# WELWYN HATFIELD COUNCIL

## PLANNING DECISION NOTICE – REFUSAL

S6/2007/1139/FP

**ERECTION OF A TWO STOREY SIDE EXTENSION INCLUDING DORMER WINDOWS FOLLOWING DEMOLITION OF EXISTING GARAGE**

Project: 93 The Ridgeway Cuffley
 Drawing: Proposed Scheme Plans and Elevations
 Date: July 2007
 Scale: 1:100
 Drawn: mRn 8504/P/003 b

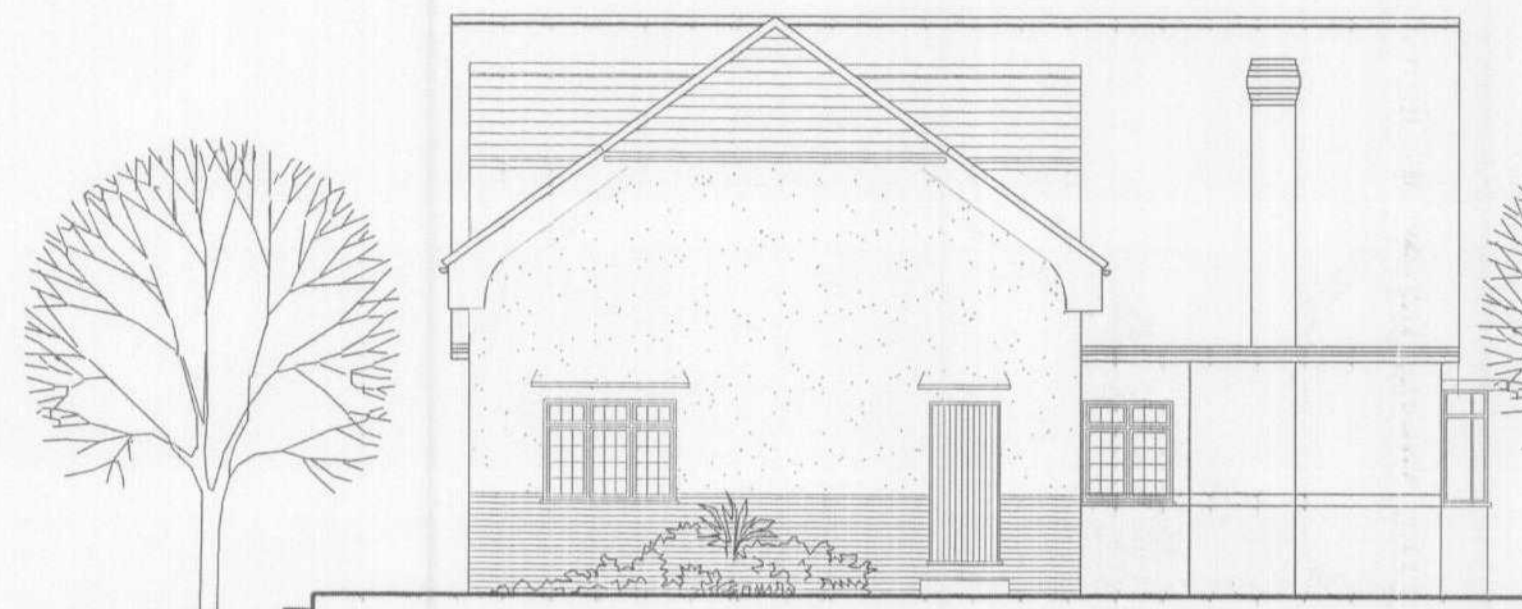
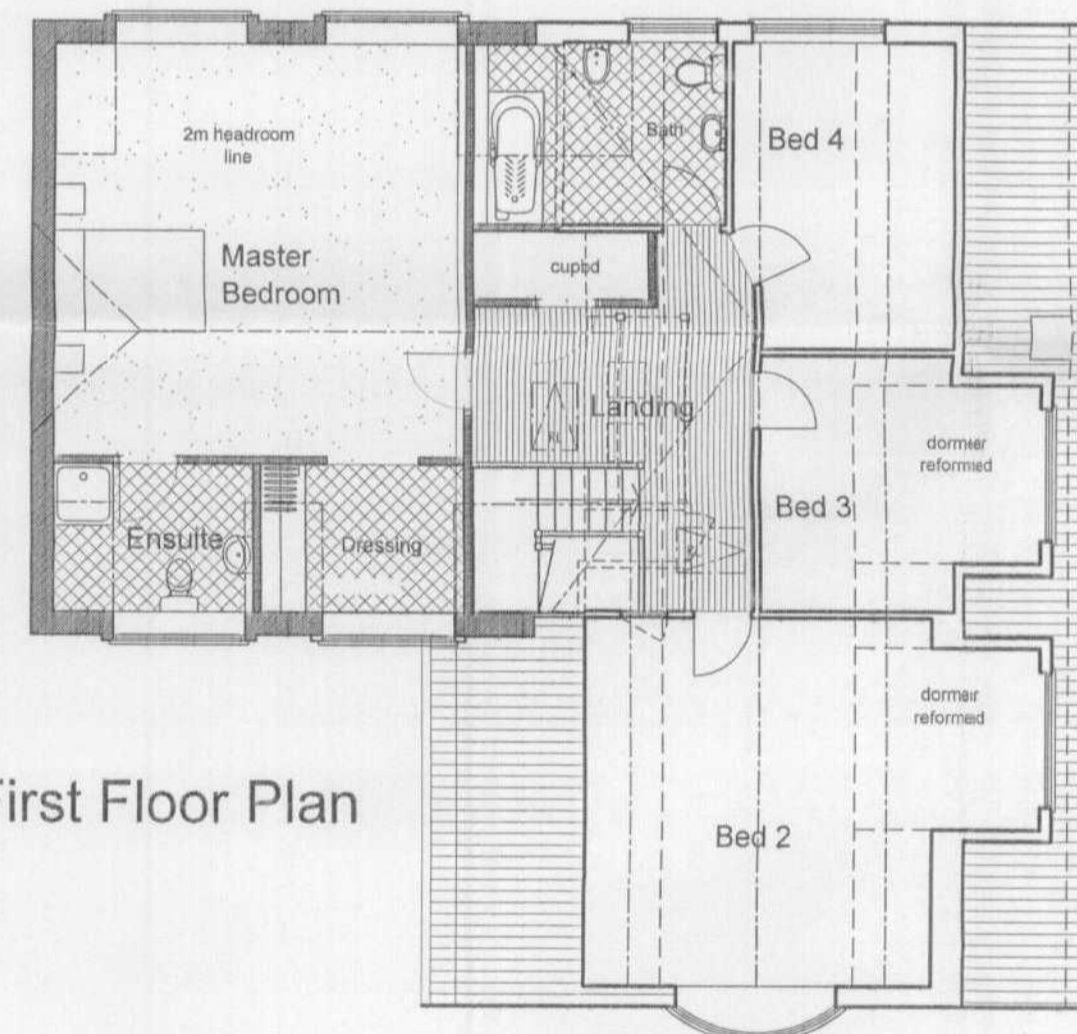
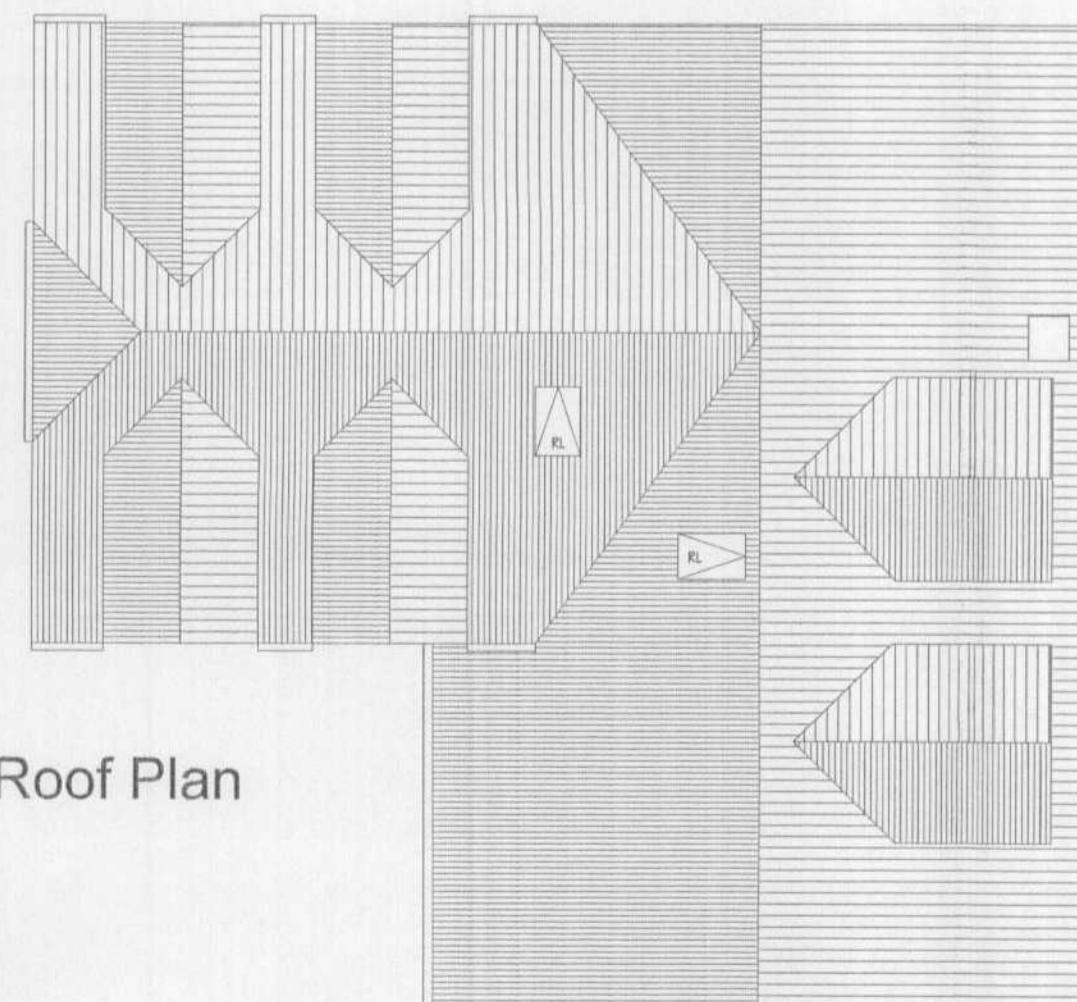
1) The proposal by virtue of the size, bulk, scale and design would result in a disproportionate addition over and above the size of the original dwelling and therefore represent inappropriate development within the Green Belt. The applicant has failed to demonstrate to the satisfaction of the Local Planning Authority any very special circumstances exist to outweigh the harm caused by reason of its inappropriateness. In addition, the proposal by virtue of its siting, design and bulk would have a detrimental impact on the character and openness of this part of the Green Belt and the visual interest of its surroundings. The proposal is therefore contrary to the advice contained within PPG2 and Policies RA3, D1 and D2 of the Welwyn Hatfield District Plan 2005 and Policy 5 of the Hertfordshire Structure Plan Review 1991-2011.
